PROJECT NAME: **Yellowstone Trails Estates Plat (LP-09-06)**

KITTITAS COUNTY LAND USE HEARING EXAMINER

IN THE MATTER OF LP-09-06 Yellowstone Trail Estates Preliminary Plat))))	RECOMMENDED FINDINGS OF FACT, CONCLUSIONS OF LAW, DECISION AND CONDITIONS OF APPROVAL
---	------------------	--

PLAT OF YELLOWSTONE TRAIL ESTATES
A PTN. OF THE EAST 1/2 OF SECTION 9, T.22N., R.11E., W.M.
KITTITAS COUNTY, WASHINGTON

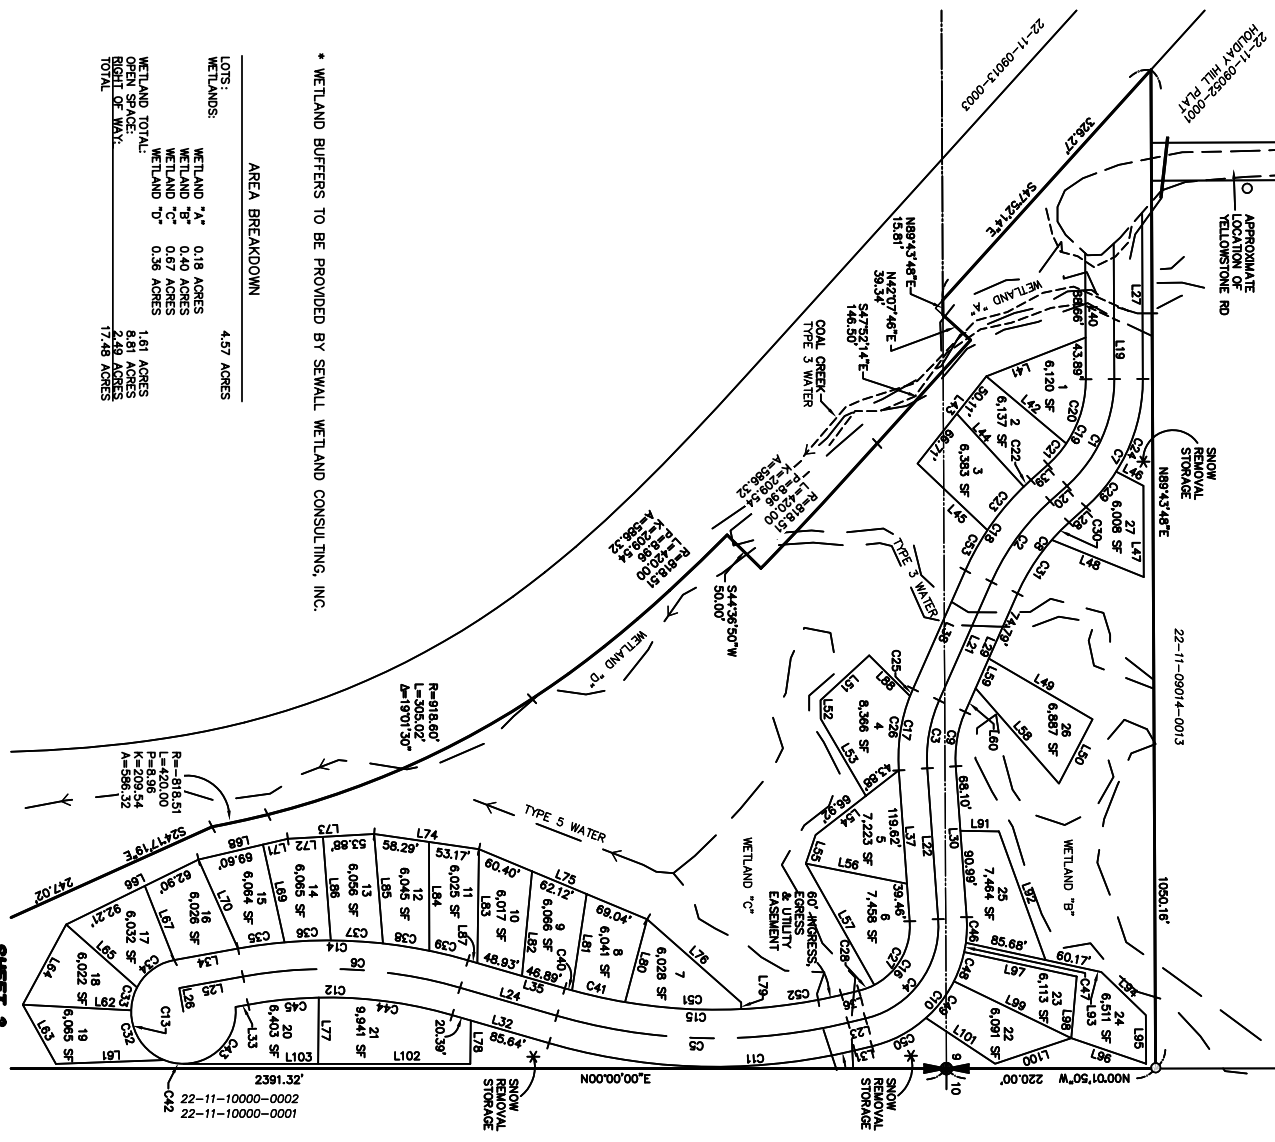
22. Christina Wollman, from Kittitas County Public Works, stated that they had concerns with Lot 24 in that it was a flag lot and that the driveway was not of sufficient width to allow for adequate snow removal without impacting neighbors' driveways. She stated that the driveway should be at least 20 feet wide to accommodate snow removal. (Open record public hearing testimony)

13. Lot 24 Access: Lot 24 is accessed by a 121' long by 10' wide driveway. Based on an average snow accumulation of over 35-feet, a 10' wide driveway of this length will place an excessive burden on the homeowner during snow removal, and may cause issues with the neighbors in Lots 25, 23 and 22. Please see the attached photos which show snowfall on Yellowstone Road. Public Works recommends the lots be adjusted to allow all lots direct access to the private road.

accessory structures, without the need for a variance. Mr. Nelsen testified that he was not previously aware of Public Works' position regarding the driveway for Lot 24. He testified that they would work to adjust the driveway as necessary to accommodate snow removal. (Open record public hearing testimony)
